# WOODMEN FRONTAGE ROAD TURN LANE

## PUBLIC IMPROVEMENT CONSTRUCTION PLANS

PUBLIC IMPROVEMENT CONSTRUCTION PLANS  
WOODMEN FRONTAGE RD. TURN LANE  
FOR  
CHALLENGER COMMUNITIES, LLC

C0.0

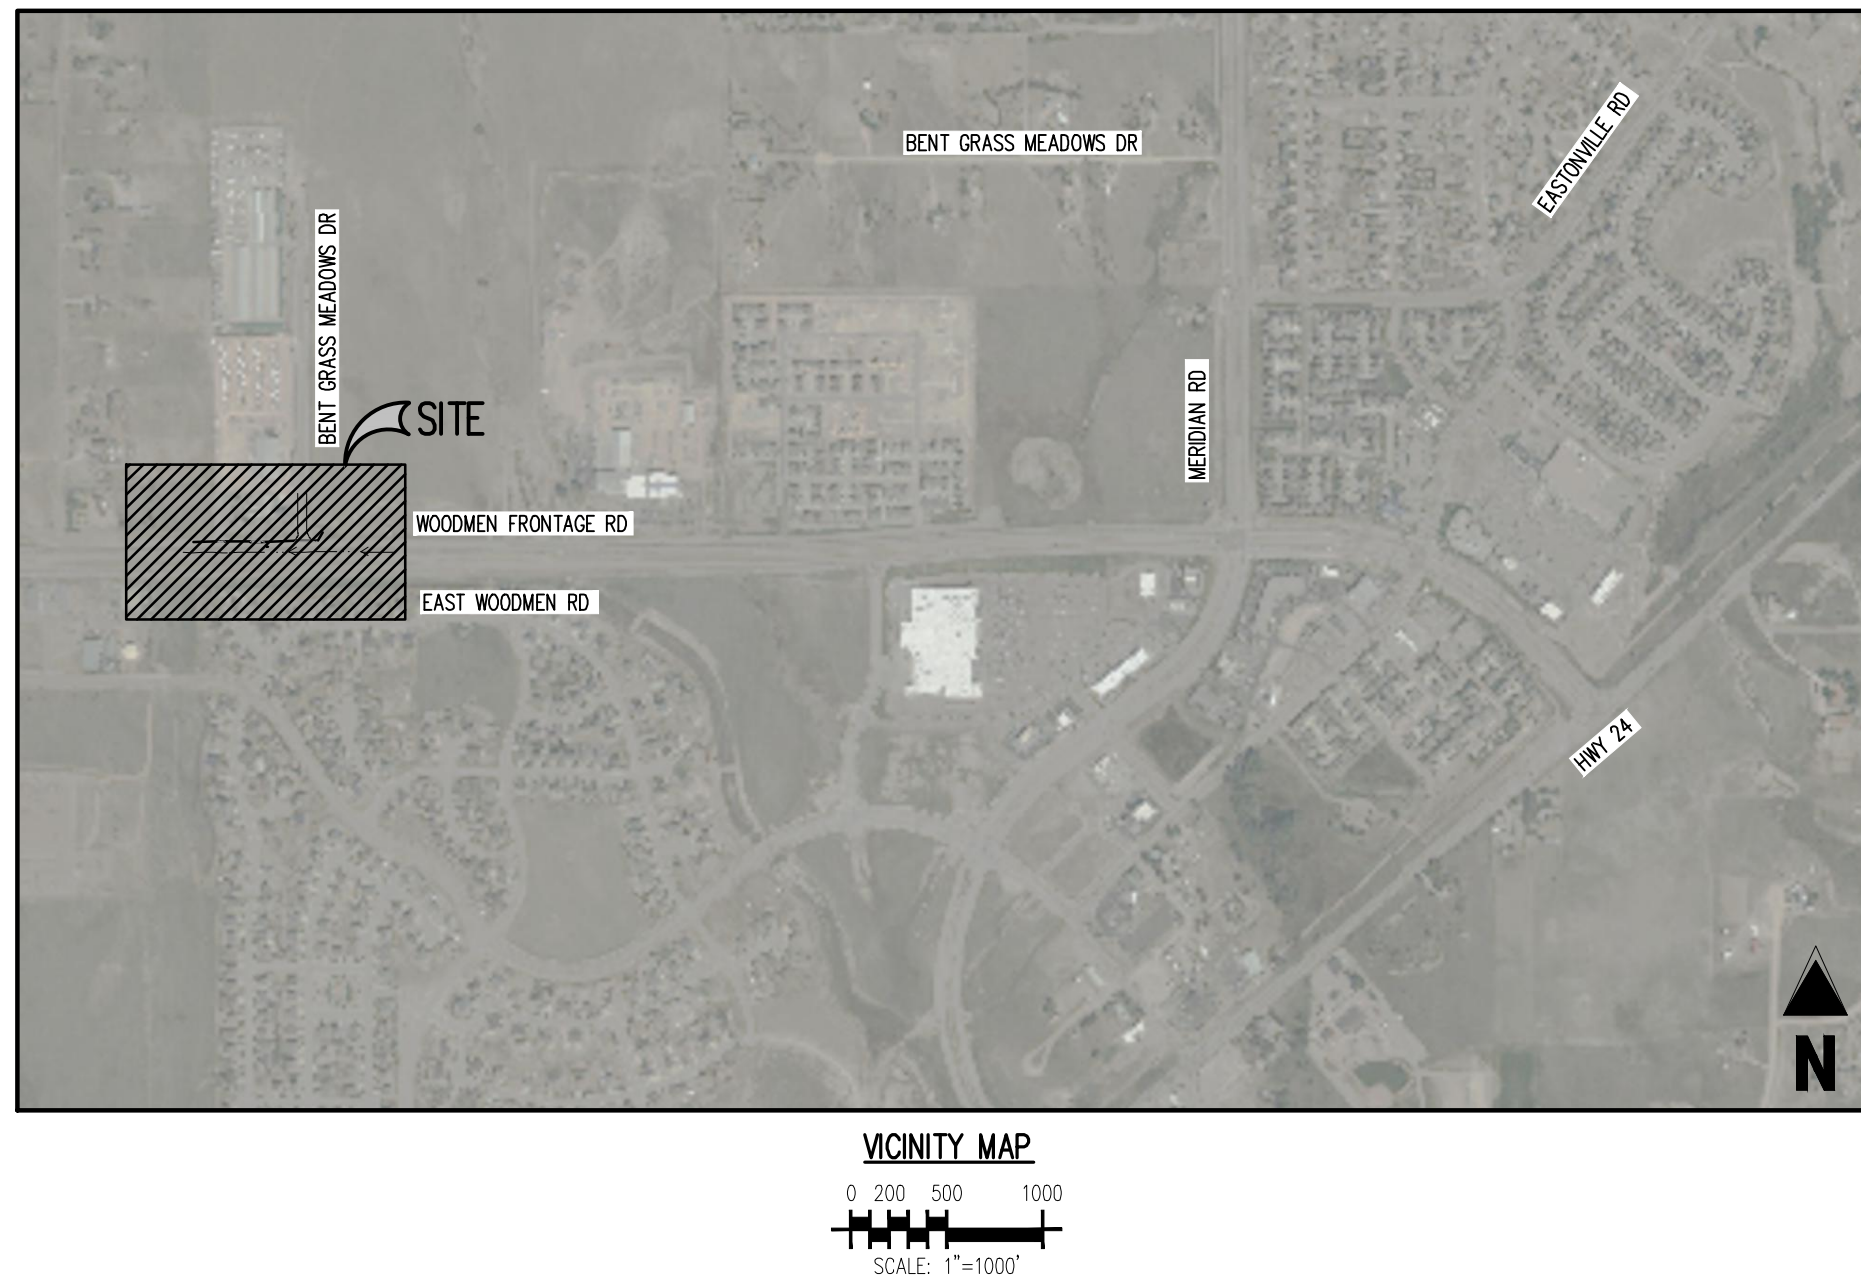
Update sheet index

Provide an erosion control plan.

added label

Separate GEC plan submitted
